Moolarben Coal Complex Stage 2 _ Preferred Project Report 08_135

I wish to lodge my objection to the Moolarben Coal Complex (MCC) Stage 2 Preferred Project Report (PPR). This proposal falls well short of the environmental requirements that would be necessary to offset and mitigate the prospective water catchment degradation and biodiversity loss emanating from this mine. It fails to provide adequate compensation to the local community and future generations for the scale and impact of the project predicted to endure in excess of 100 years.

Fig 2.5 - MCC Transect 4 - with Drip seepage zone height corrected to 8-12m  
PZ129 superimposed (depth to scale - from LOG)

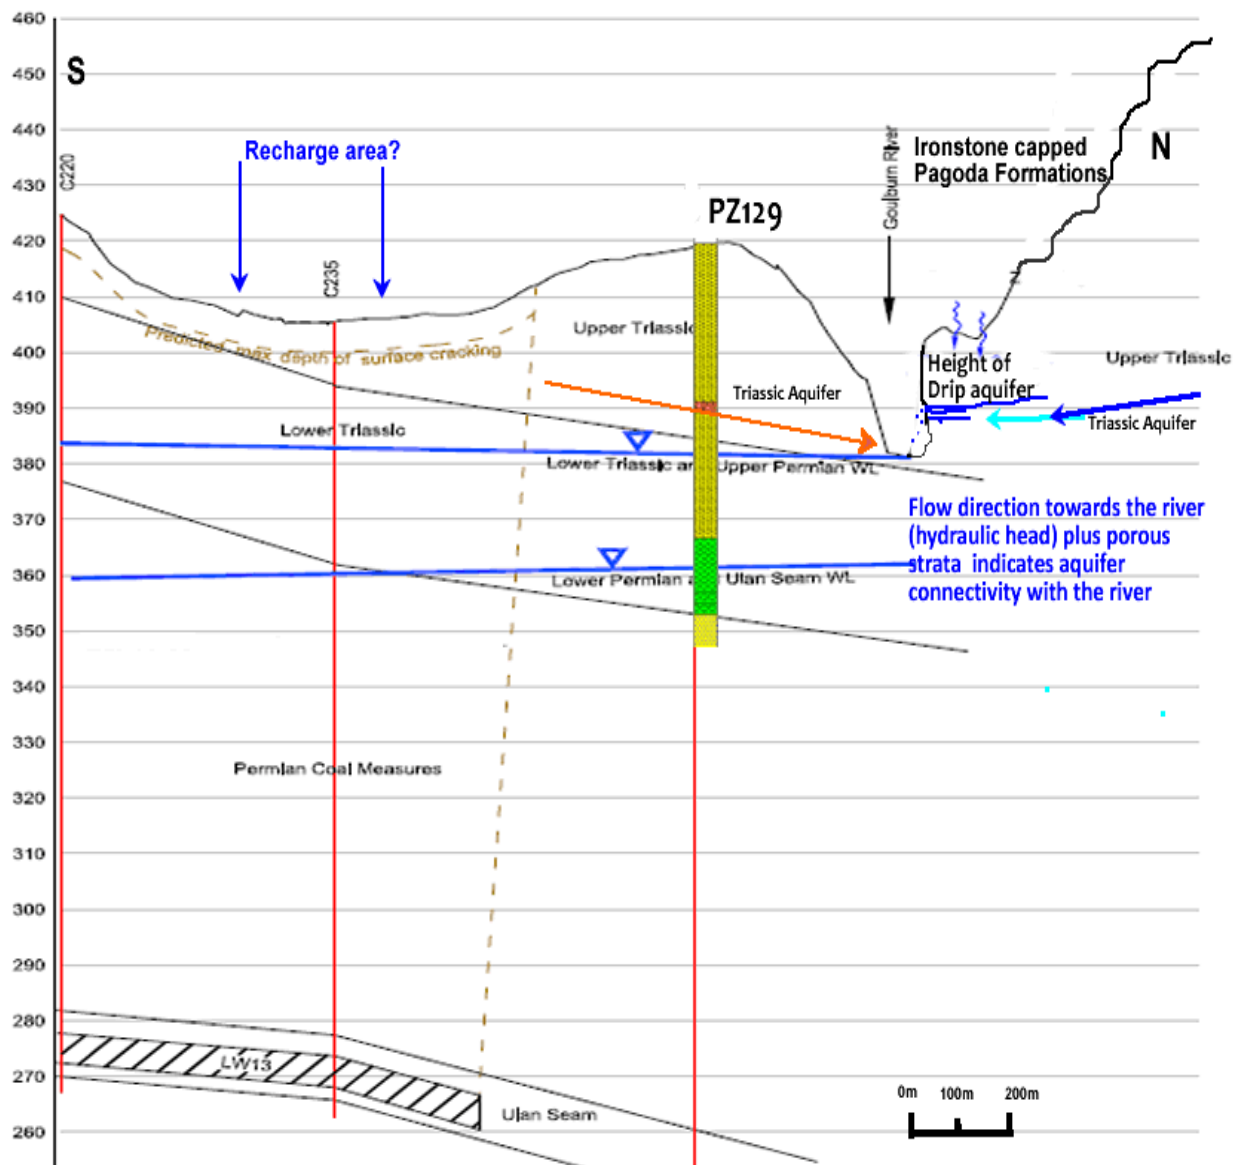
Increased vertical hydraulic permeability due to mine subsidence occurred above UCML underground prior to 2006 and the installation of the wider long wall faces. Table 5.9 (p.48 MCP GIA) shows increasing mine inflows from the 1990s, accelerating in 2000-2002 wet years (from 5.6- 7.7 ML/day). Triassic Bore PZ129 has a hydraulic head range 390-393mAHD (MCC AEMR 2010-11) this is above the level of the river (~382m AHD) indicating groundwater flows towards the River (see Fig2.5).

The GDE referred to as ‘The Drip’ has not been adequately investigated or understood. Local knowledge will confirm that seepage is sustained throughout the severest of droughts; this resilience suggests it is fed by a permanent groundwater source located above the ‘dripping’ discharge area (~ 390 mAHD - halfway up the cliff face). While the aquifer would obviously rely on replenishment from rainfall events, it may also be sustained from upward pressure from joint or fault connecting it to the Triassic aquifer system (Pz129 = 389-392 mAHD) and therefore could be potentially drained if the Triassic Aquifer was depressurised. The water level in hydraulic head of Triassic Bore PZ 129c (opposite The Drip) indicates groundwater flow towards the river.
